From: Laurence Moore [REDACTED]
Sent: 17 August 2022 15:46
To: Anita Gardner <Anita.Gardner@arun.gov.uk>
Subject: RE: A/43/22/PL.

Subject: A/43/22/PL.

Drawing title
Landscape General Arrangement Plan

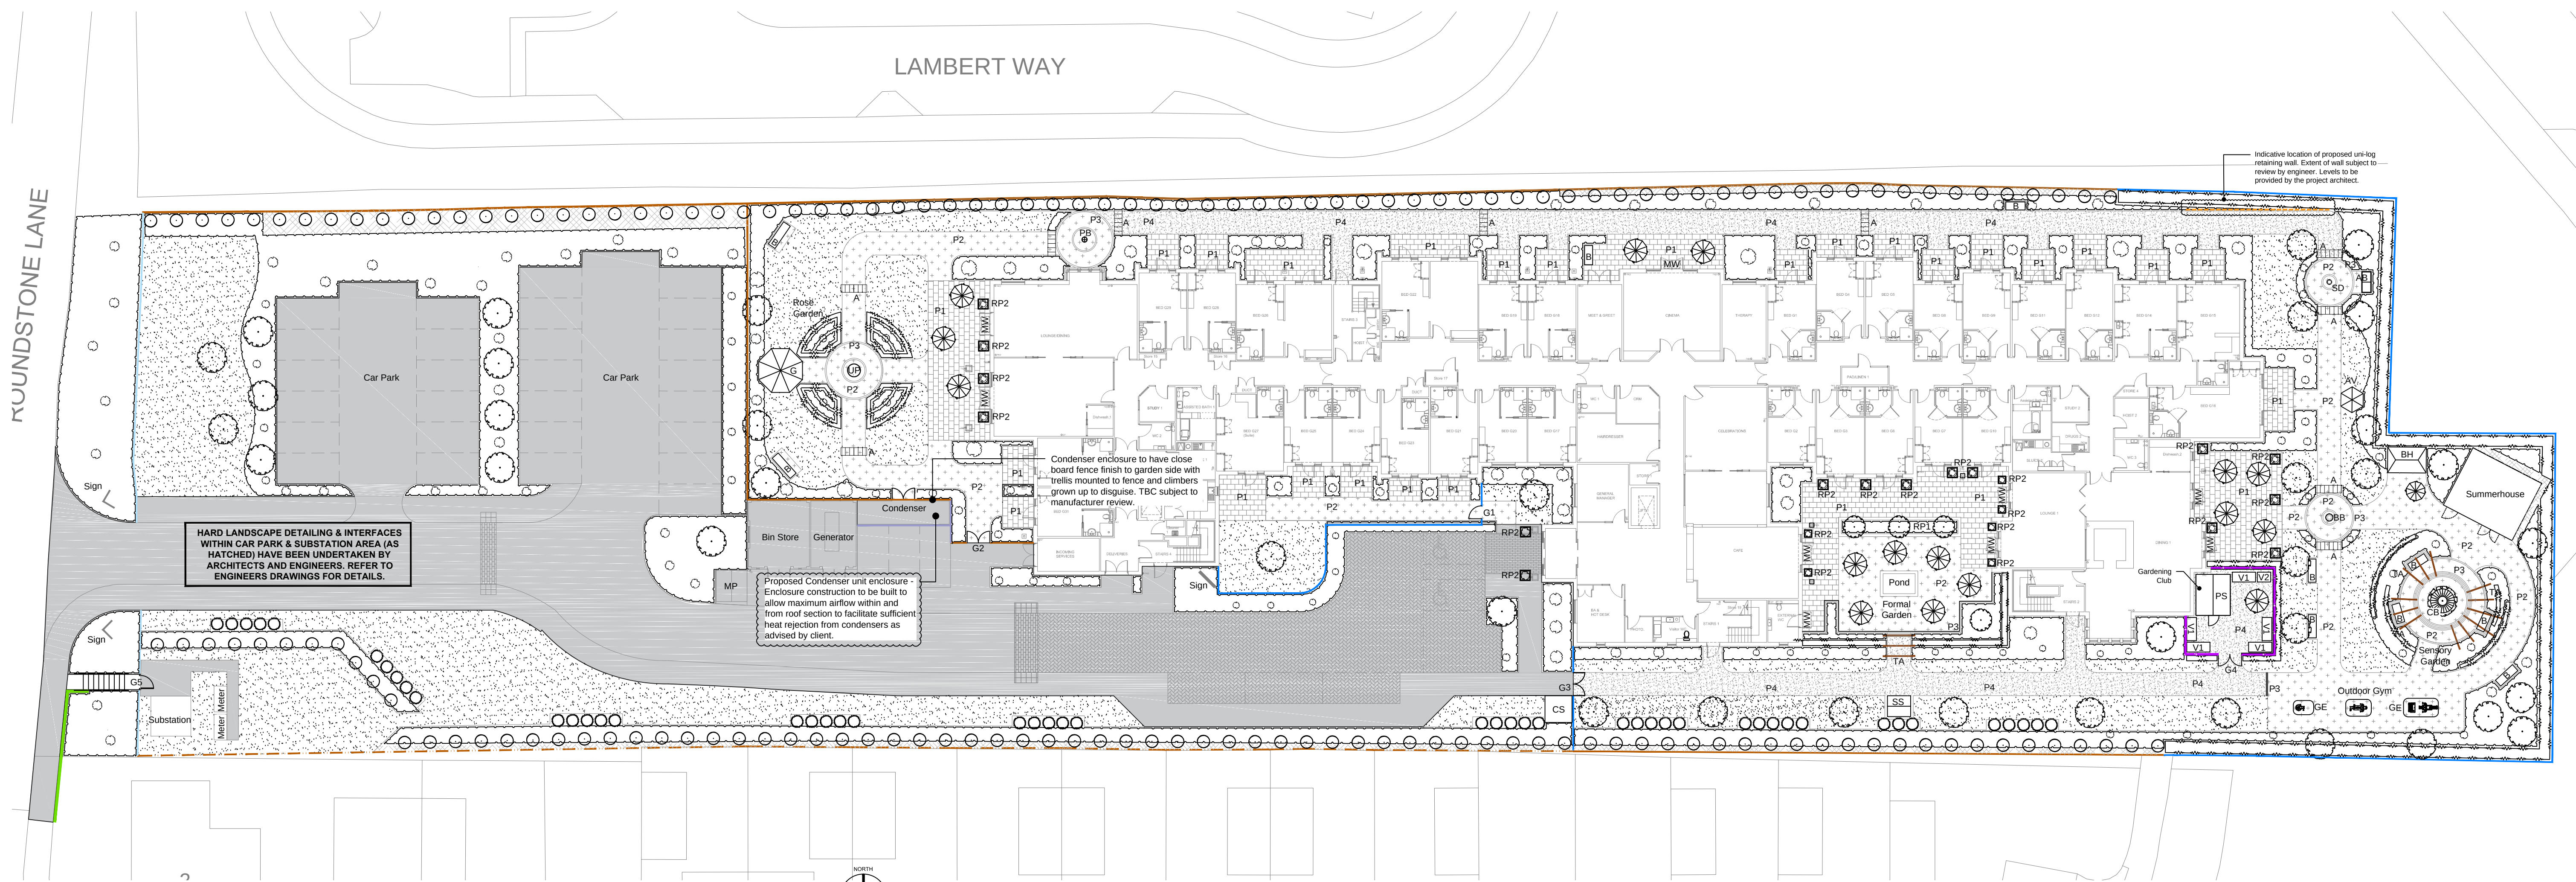
I have now had an opportunity to discuss the application with my Team Leader, Juan Baeza and he agrees that the items detailed in my e-mails below namely bbq hut, summerhouse, hoop top fencing and removal of TPOd trees should be deleted from the application if it is to be recommended for approval by officers.

Further to our emails last week, I can advise the applicant is instructing architects and landscaping consultant to submit amended drawings to address your comments regarding summerhouse, bbq, and trees. I'll update you when the amended plans are likely to be submitted to you. We are hopeful they can be submitted soon.
